MAJOR PROJECT ASSESSMENT
MP09_0033

***Project Application for Residential Development
3 – 5 Pymble Avenue and 5A (access handle only)
Pymble Avenue, Pymble***

Director-General's Environmental Assessment Report
Section 75I of the
Environmental Planning and Assessment Act 1979

15 July 2009

E LEVEL 03 - ARCH 100
SCALE 1:100

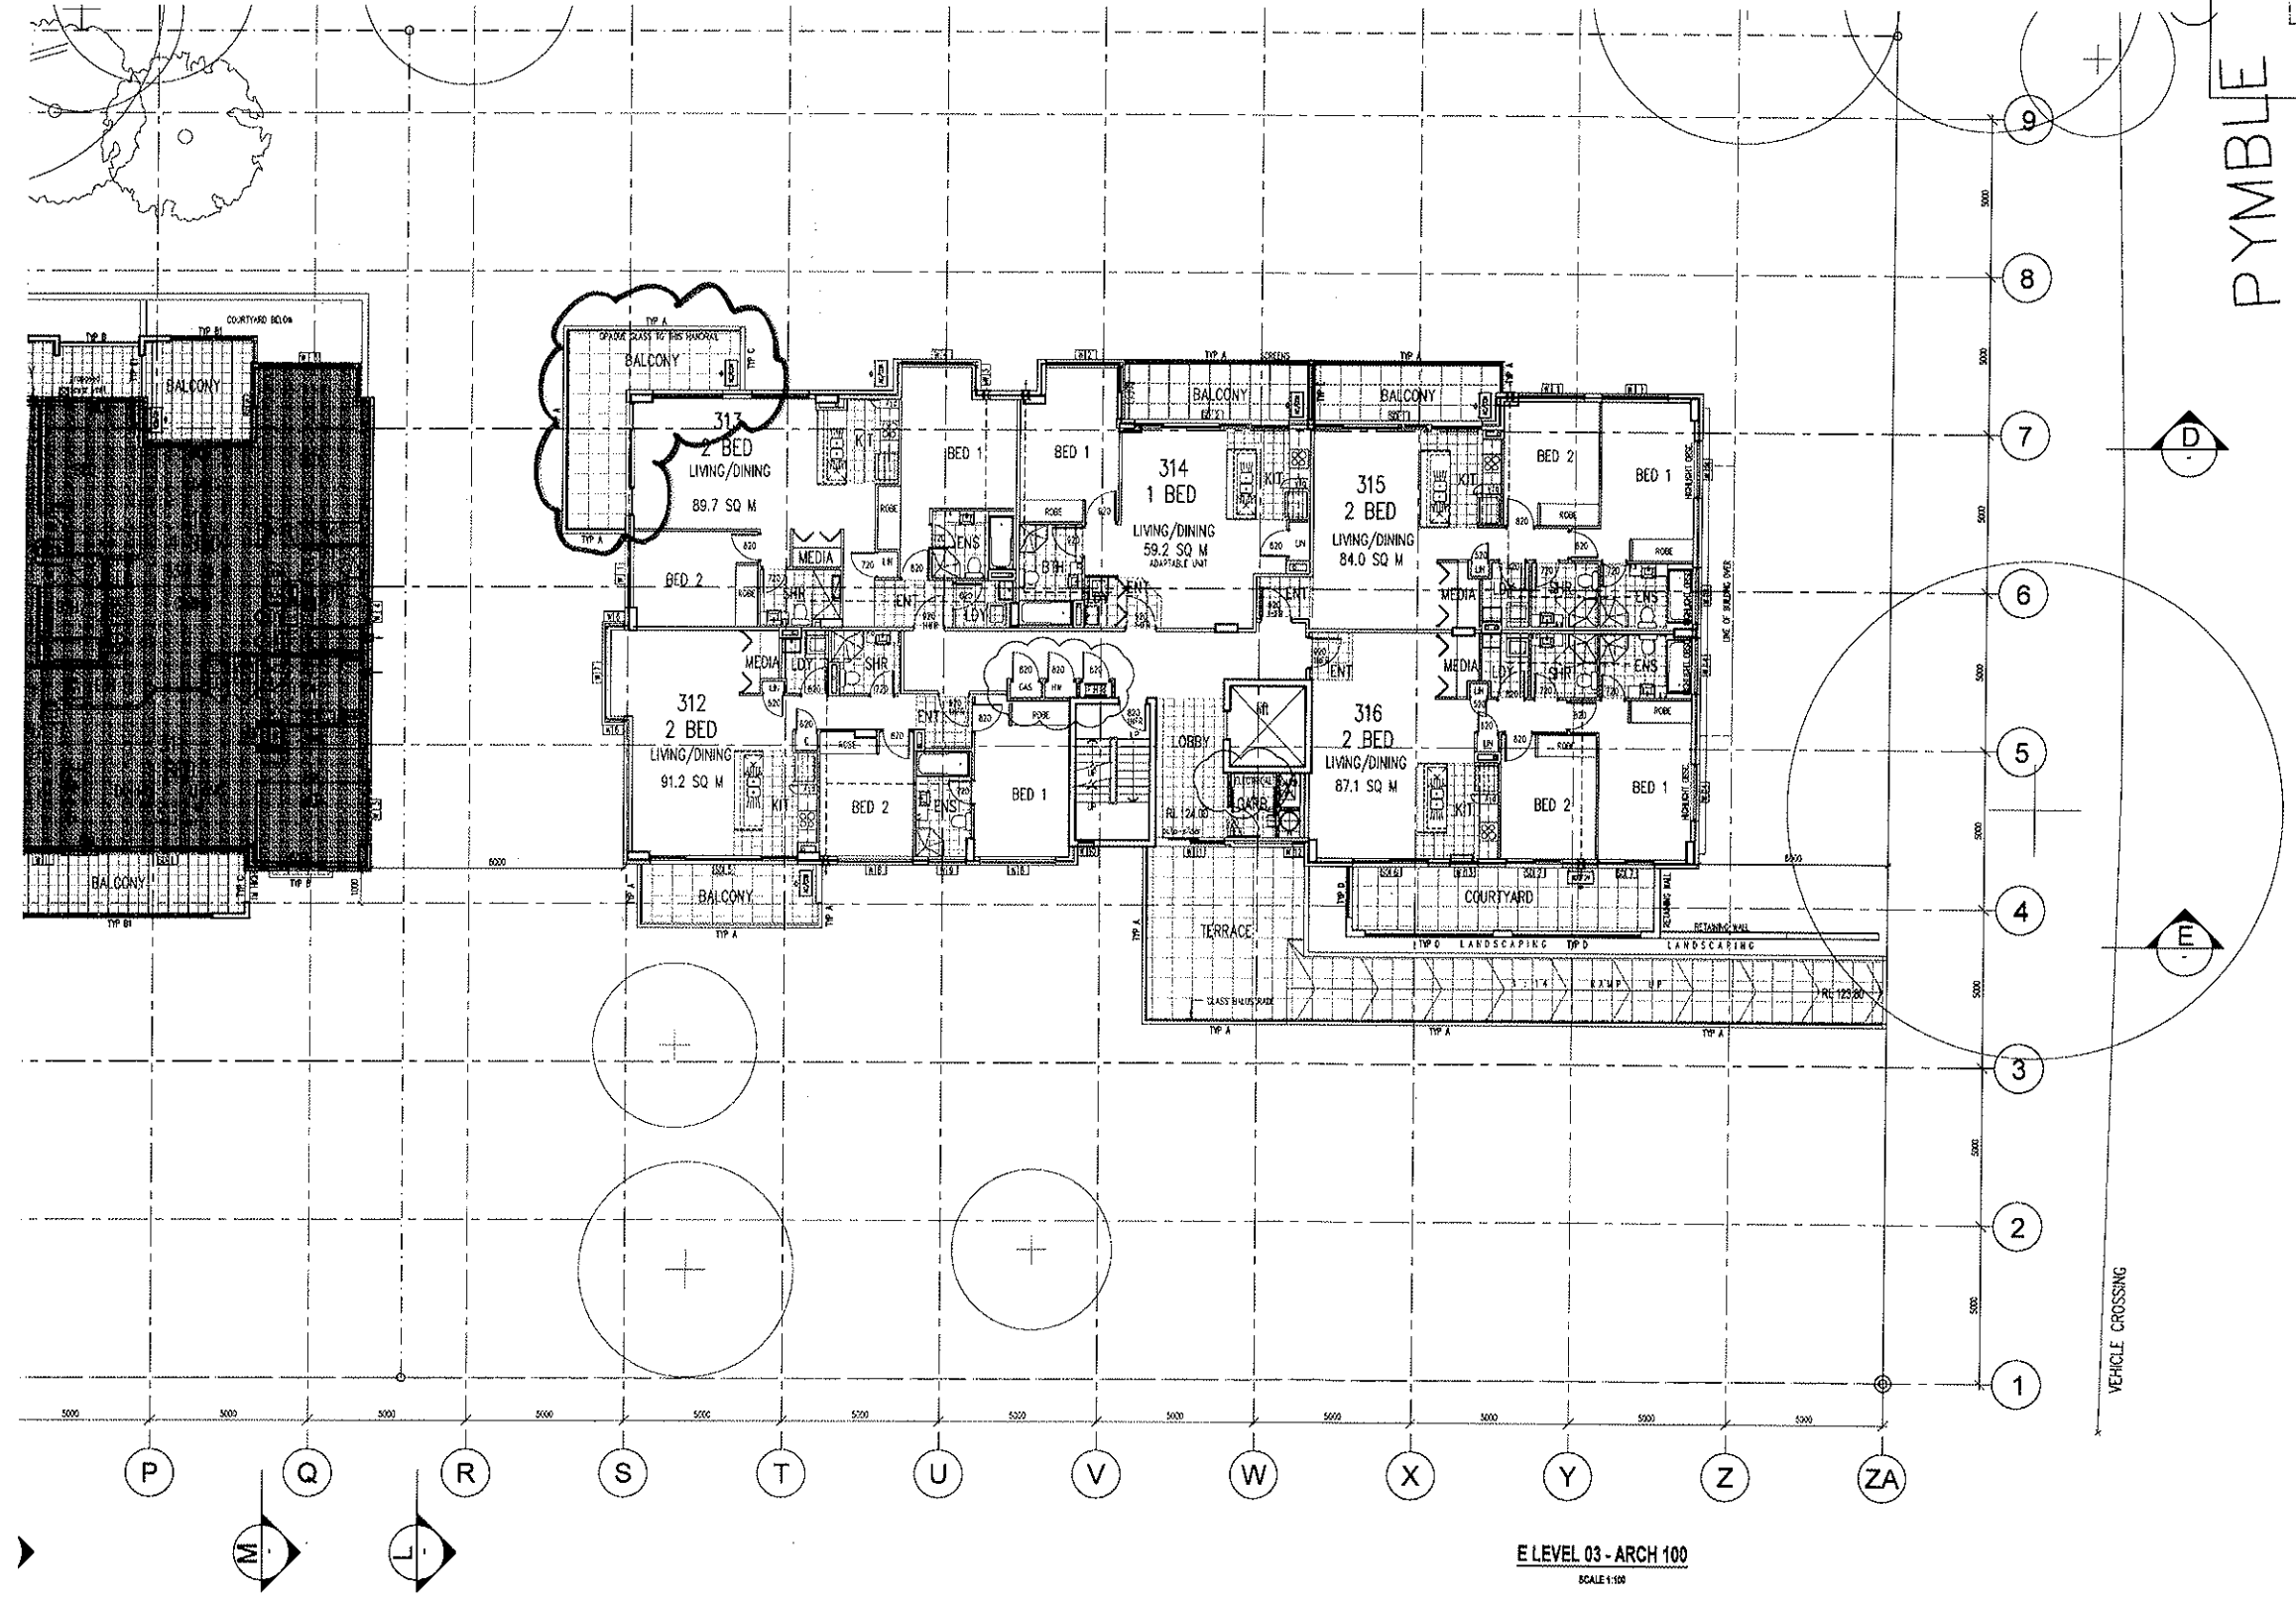
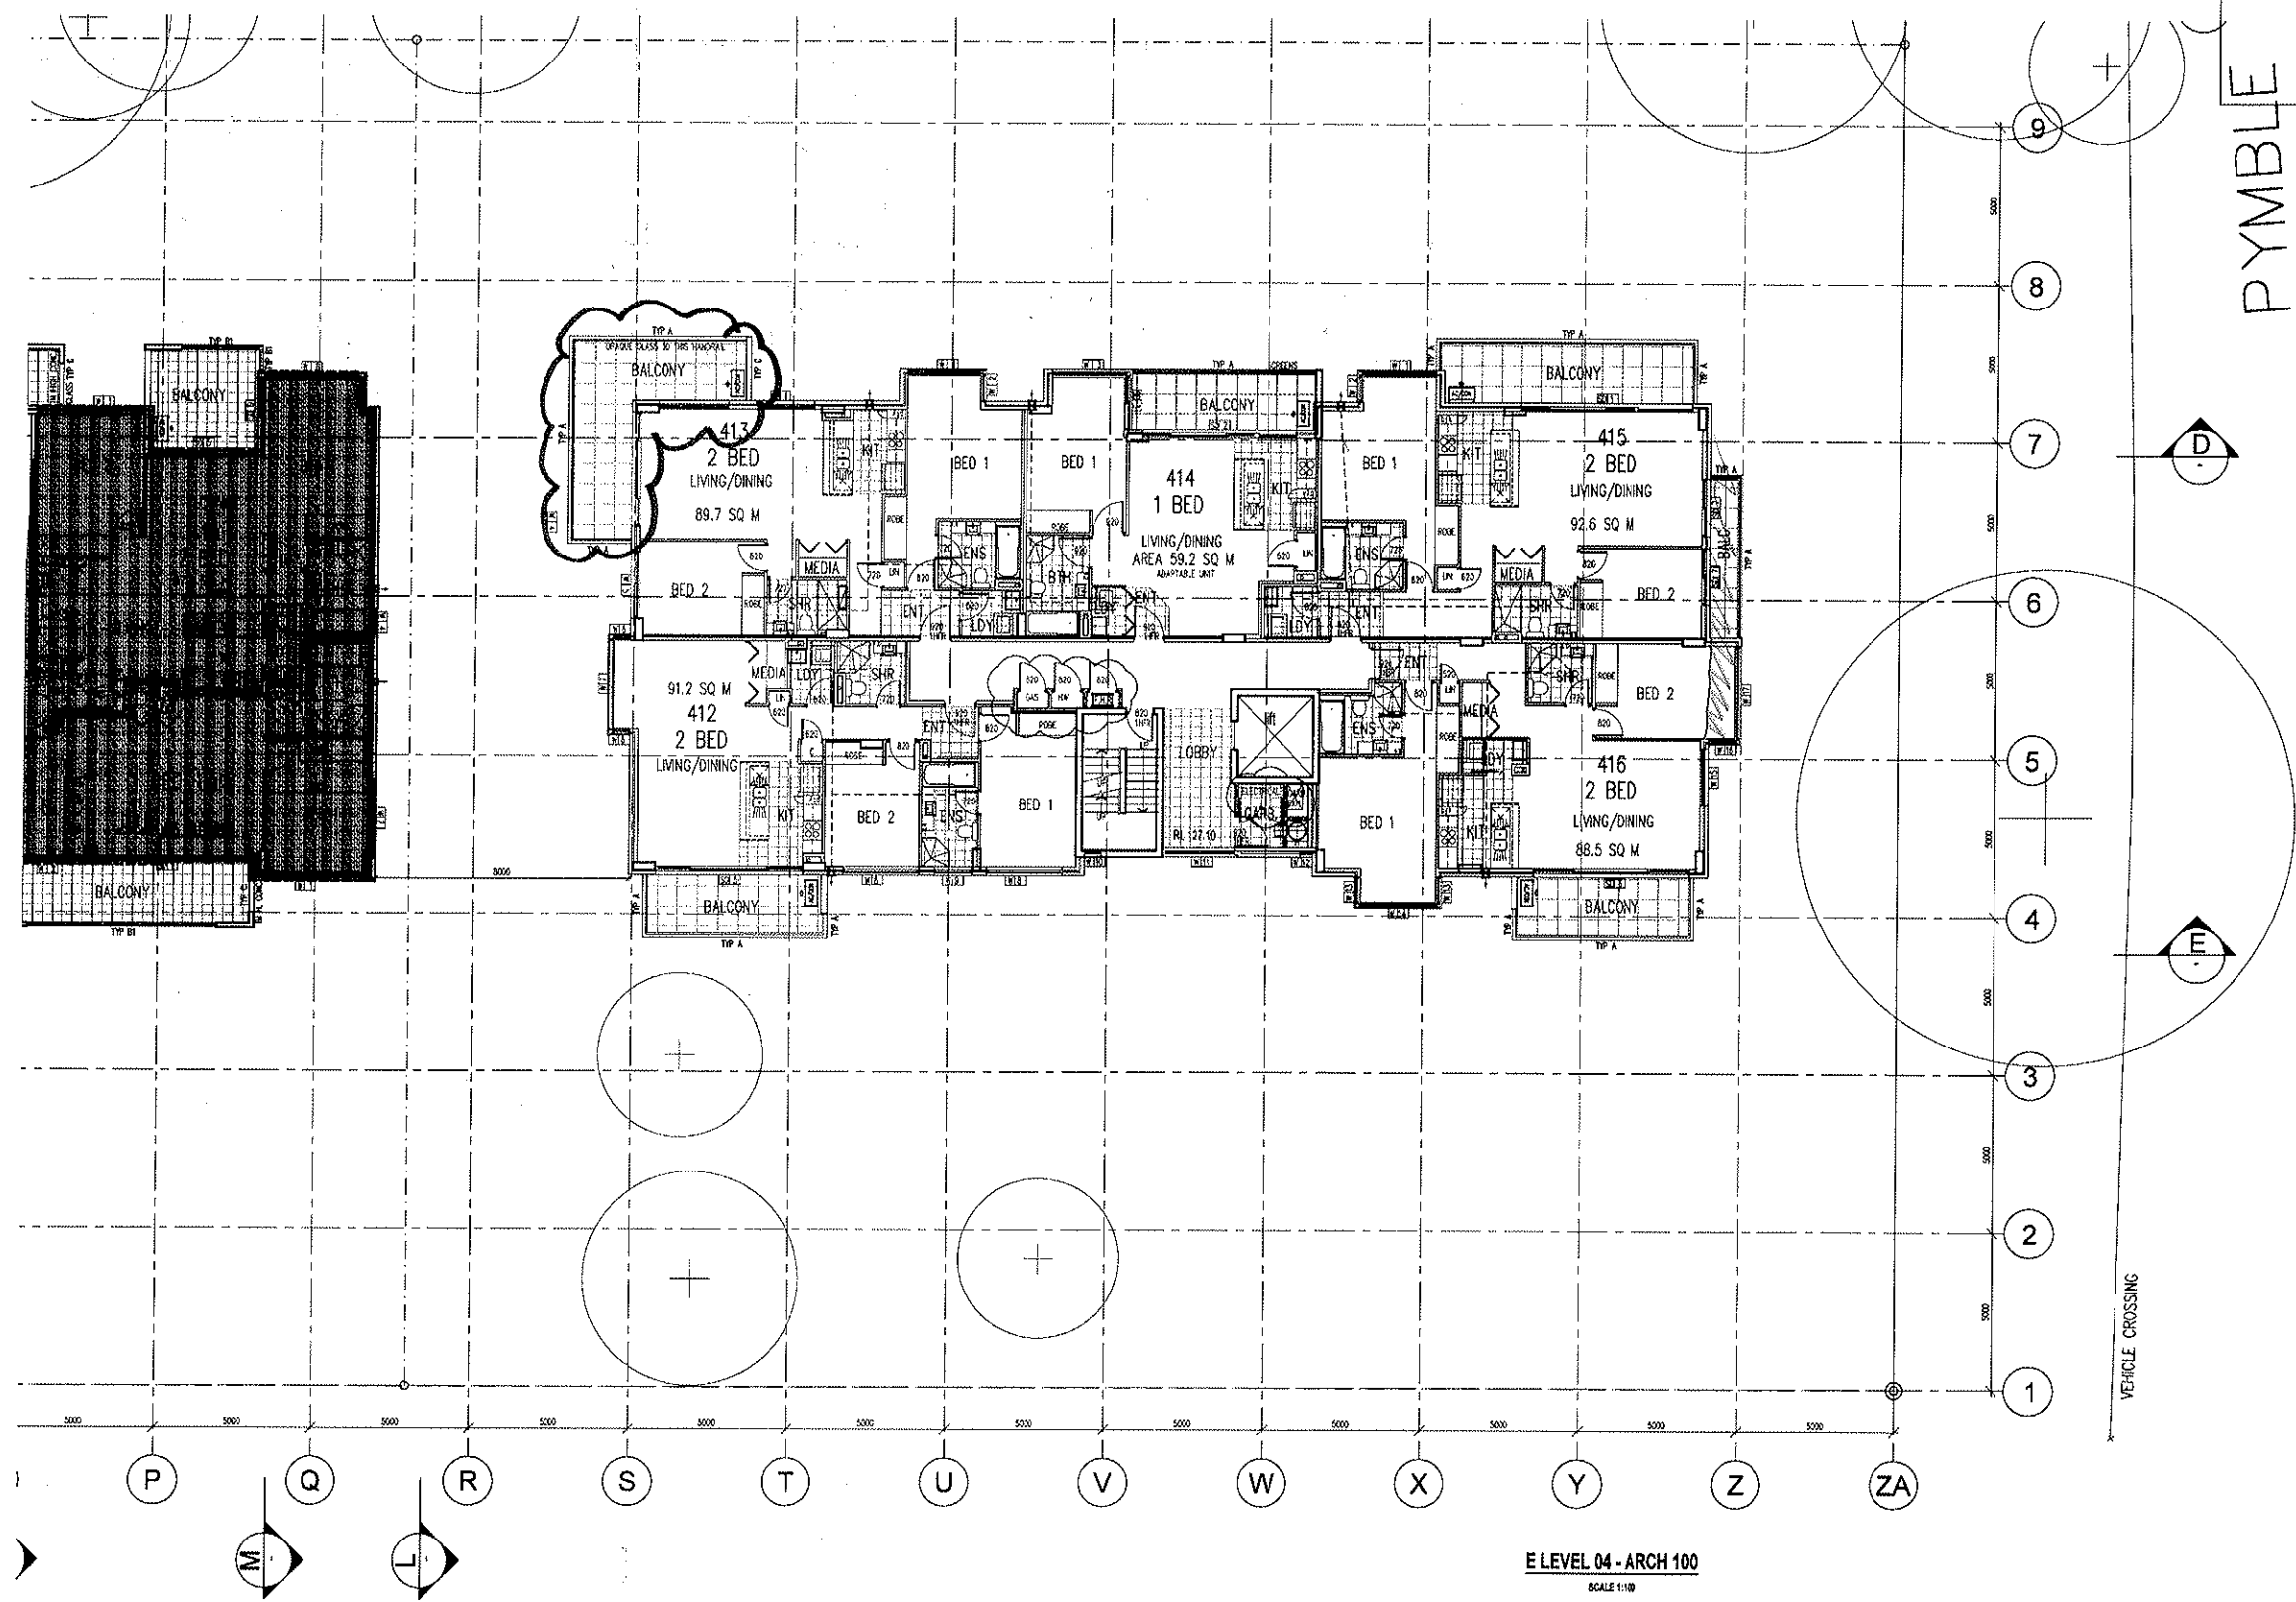
- Altered the orientation and location of the proposed balconies on the north western corner of the building so that their orientation is north-west, away from the adjoining dwellings (refer Diagram 2 above).
- Submitted a site plan showing the detailed location of the neighbouring dwellings (1 and 1A Pymble Avenue) in relation to the proposed development (building E).
- An analysis of alternative options of providing internal vehicular access into the Block F envelope (possible future development envelope for 1 and 1A Pymble Avenue) from the broader development site.

- Introduction of various design measures to improve visual and aural privacy to neighbouring properties;
- Provision of additional landscaping; and,
- Requirements for drainage easements.
